From: Paul Cann <Paul.Cann@arun.gov.uk>
Sent: 12 December 2019 11:09
To: Planning.Responses <Planning.Responses@arun.gov.uk>
Cc: Sarah Burrow <Sarah.Burrow@arun.gov.uk>
Subject: RE: Planning Consultation on A/165/19/DOC

Comments on surface water drainage proposals in respect to conditions 14, 15 ,16 & 18;

APPLICATION NO: A/165/19/DOC

Site Address: The Laurels Dappers Lane Angmering BN16 4EN

**Project:** Oceanview Developments  
**The Laurels**  
Dappers Lane  
Angmering  
**Title:** Proposed Drainage Strategy Plan

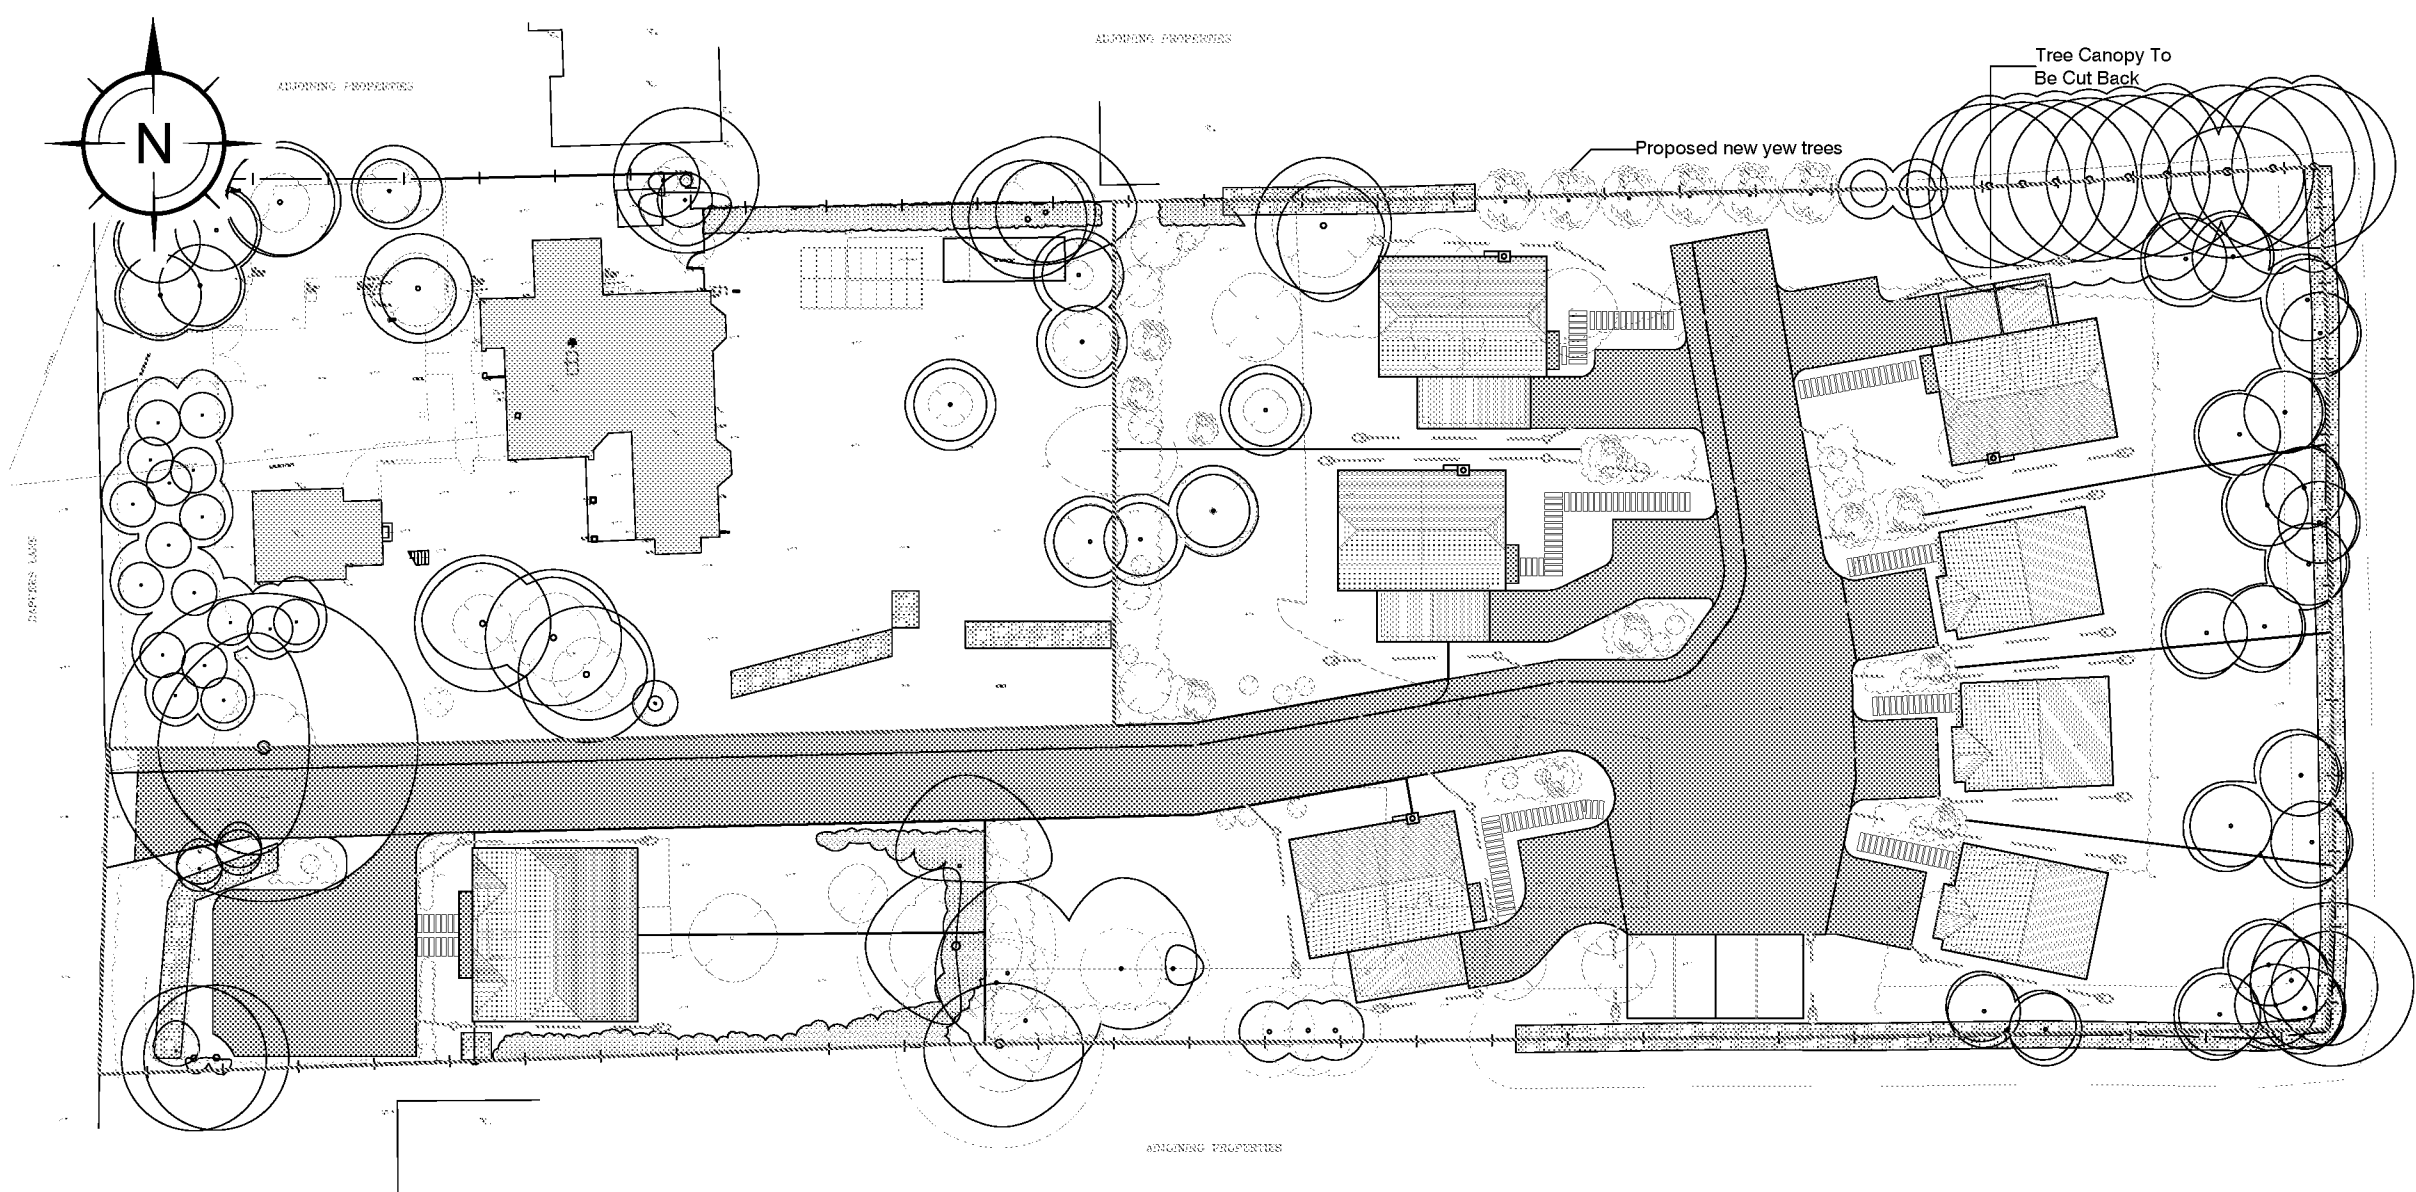
1. The applicant appears unaware that a culverted watercourse that runs along the western boundary, please provide the following on your drawings so further comments can be made;

- a) A plan showing its location.
 - b) Position/photos of any existing manholes on the culvert adjacent the site including immediately upstream/downstream.

- c) Manhole/culvert invert levels/cover levels.
 - d) Pipe diameter/material.
 - e) An internal CCTV survey inspection.
 - f) Proposed finished levels above the culvert.

- g) No new tree planting to be undertaken in the vicinity of the culvert – this needs to be made clear on the drawings.
2. Provide a fully detailed foul drainage proposals plan.

5. Whilst permeable paving is likely to be the way forward, due to the lie of the land, the design will need to ensure that water does not all run to the lower end of the site via the sub base, so the paving will need be compartmented to ensure that water is contained within each structure. This arrangement will need to be fully detailed in terms of construction details and proposed finished/bed levels and supported by storage/infiltration calculations for each section. Please note that on the example calculation sheets, a porosity value of 0.95 has been used – Whilst this is acceptable for permavoid blocks, granular stone should be 30%, so the calculations will need to reflect the construction of each specific section of permeable paving. Where stone is to be used, this is to be type 3 material (of specified grading/no fines) wrapped in a permeable membrane.

6. The roof drainage should discharge into the permeable paving via diffuser block units rather than a perforated pipe network. Please also ensure that the diffuser units are kept at least 5 metres from buildings.

7. The drainage layout will need to be fully detailed in terms of cover levels/invert levels/pipe diameters/pipe materials/pipe gradients, etc.
8. Full construction details of manholes/pipe bedding/diffuser units, etc will be required.

9. Sump manholes will be required immediately upstream of all diffuser units.
10. The maintenance manual will need to take the form of a more formal manual, rather than form part of technical note. This will need to include details of how the management company will be funded. The frequency and nature of maintenance for each suds component (in accordance with that detailed in the suds manual C753) needs to be included in table format so that it is clear to the management company as to what is required, rather than just making reference to chapters in the suds manual. The suds components, not only need to consider the permeable paving, but also the maintenance of pipes/manholes/diffuser units. The future maintenance of the culverted watercourse on the western boundary should also be included. Please note that the approved drainage drawings/calculations will need to be incorporated within the manual.
